## SPR EA1N and EA2 PROJECTS

### DEADLINE 10 – COMMENTS ON APPLICANTS TOPIC POSITION STATEMENTS

**Interested Party:** SASES      **PINS Refs:** 20024106 & 20024110

**Date:** 6 May 2021      **Issue:** 1

Figure 5: Outline Landscape Mitigation Plan and Relevant Heritage Assets in the vicinity of Friston

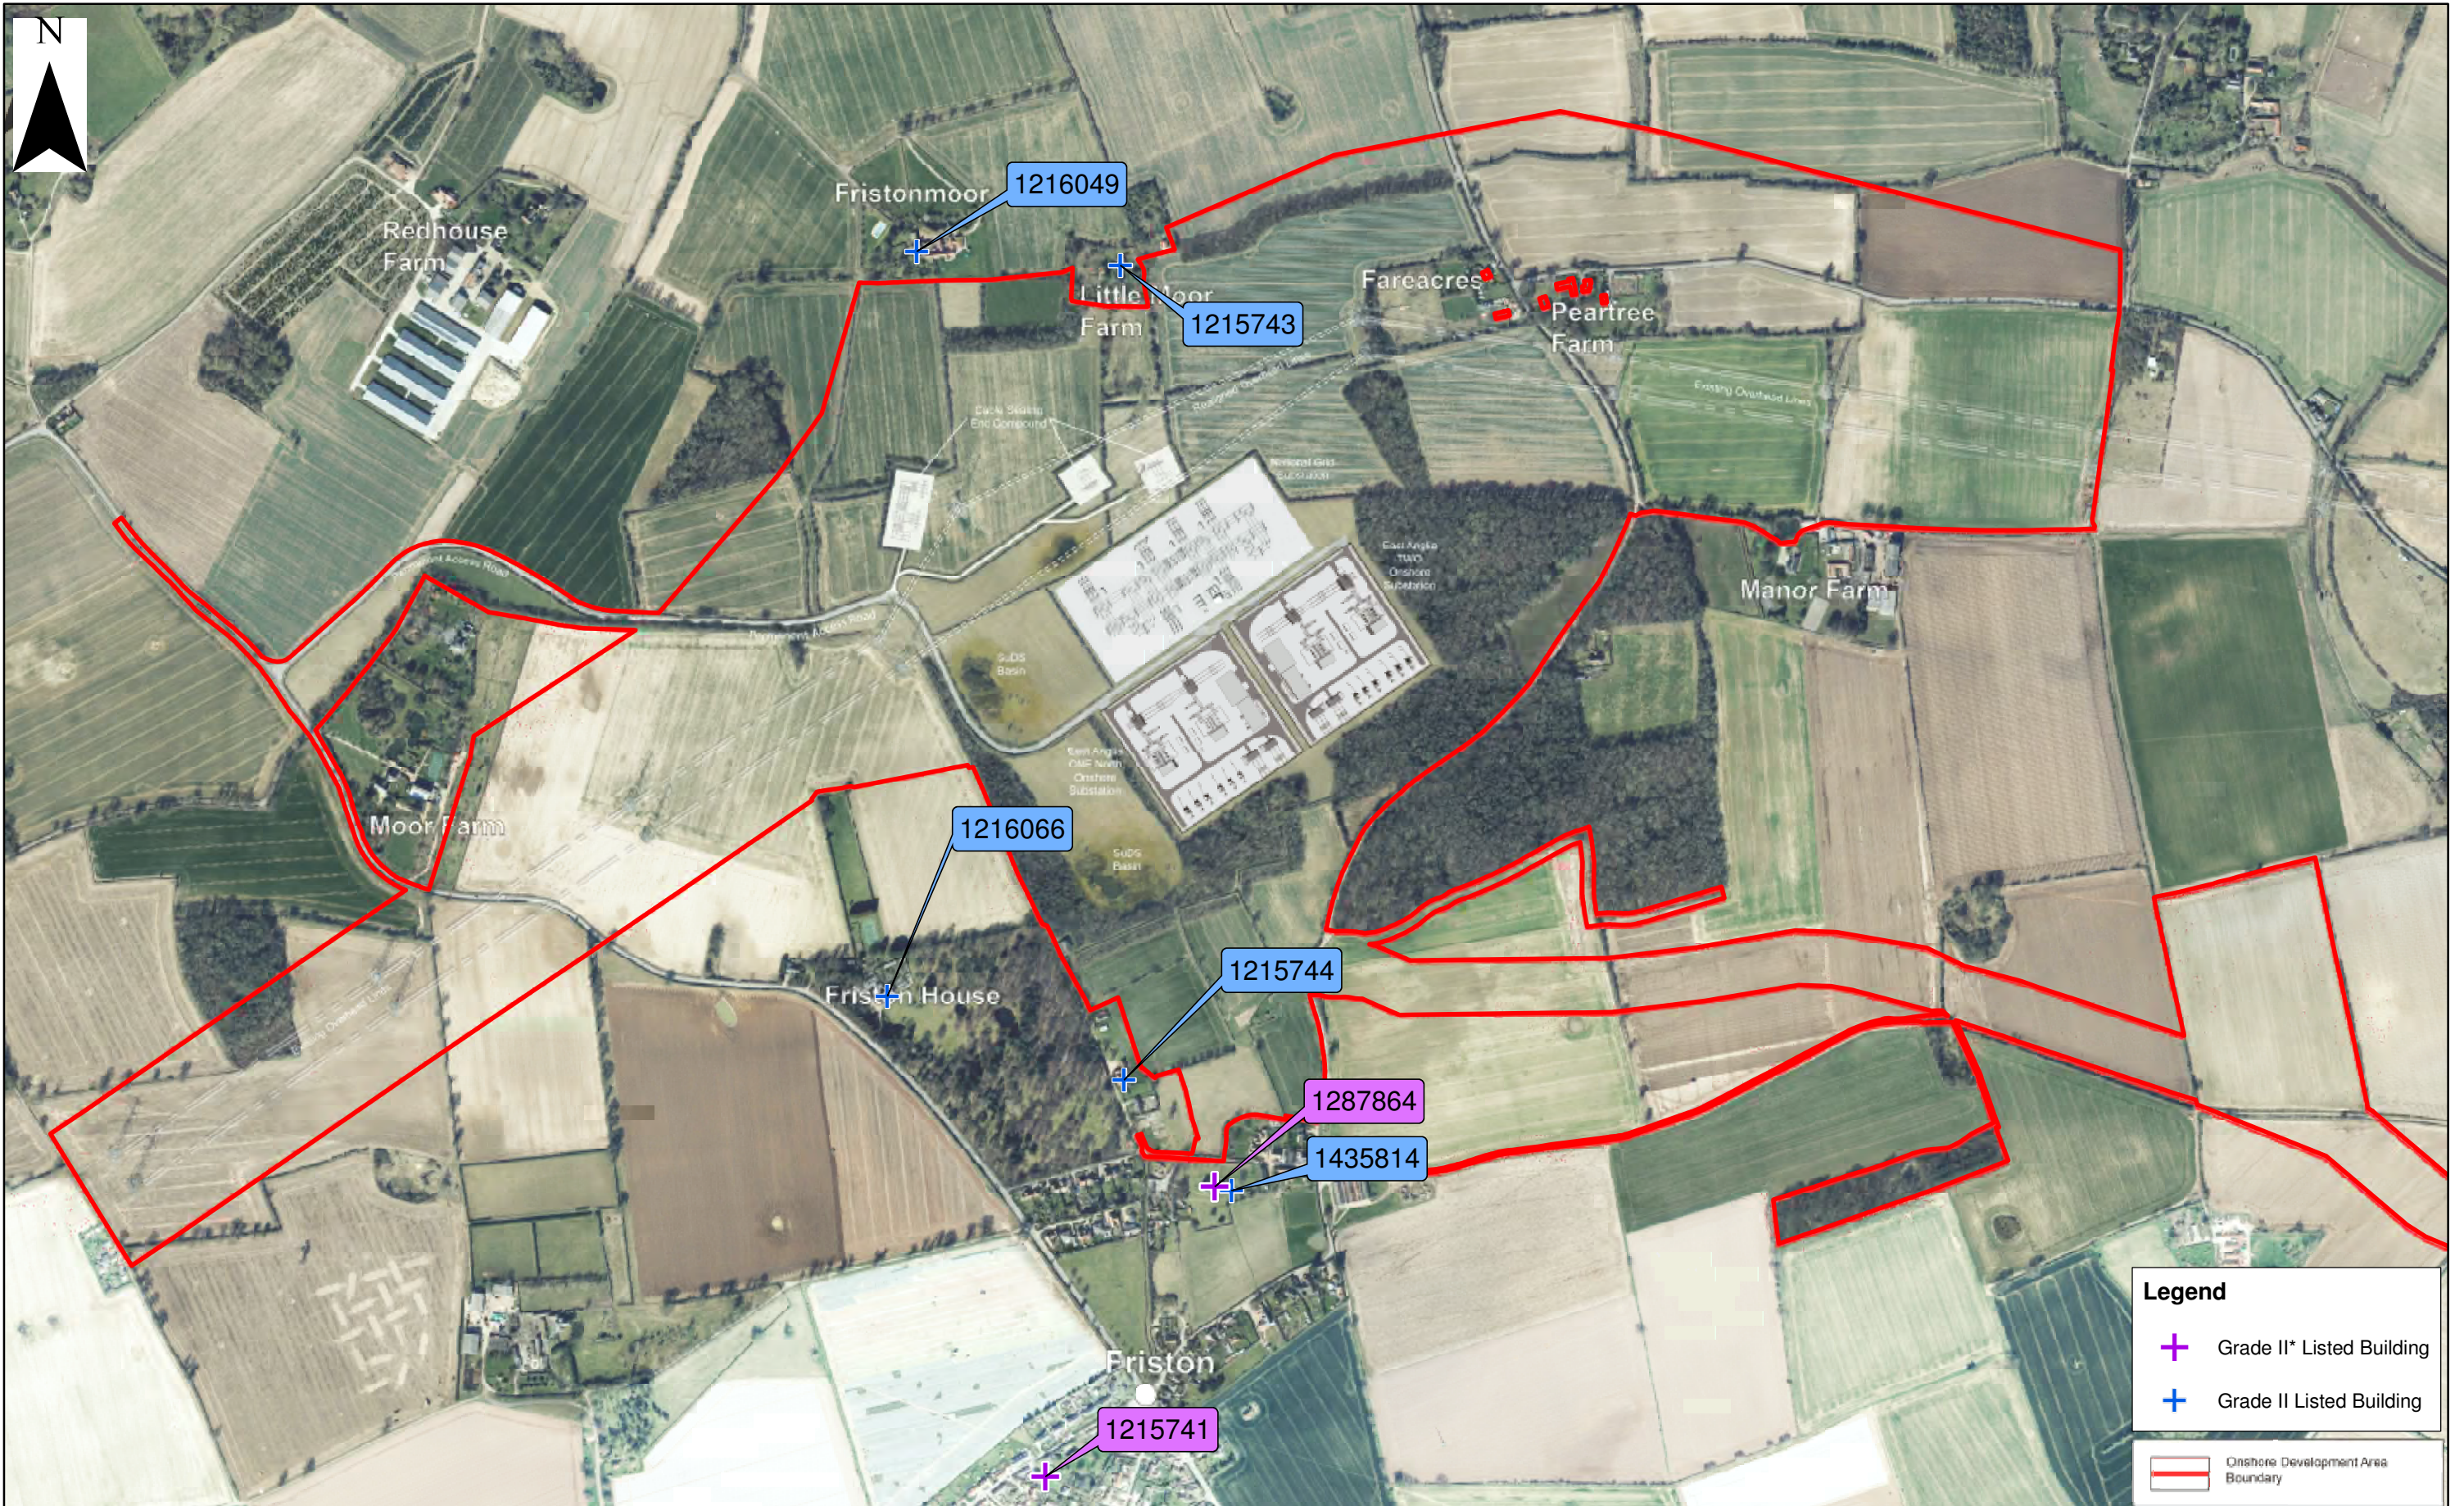
49. As set out in SASES written representations submitted at Deadline 1 (REP1-366) which were discussed at ISH2, the Applicant's assessments underestimate the heritage impact of the proposed schemes and undervalue the contribution made by setting to each of these heritage assets resulting in a much lower assessment of the adverse heritage impact. On a proper assessment, the harm to designated heritage assets is far greater than that suggested by the Applicants. The outline landscape mitigation plan does nothing to reduce the heritage impacts of the schemes in any meaningful way.

51. Whilst the Applicants have made attempts to reduce the heritage impact of its proposals through reducing the footprint and height of the Scottish Power substations, together with an immaterial 70 cm reduction in the finished ground level of the National Grid substation, this does not reduce the heritage impacts (REP4-108). The ability to reduce finished ground levels is unproven and doubtful given the surface water flood risk at the site.
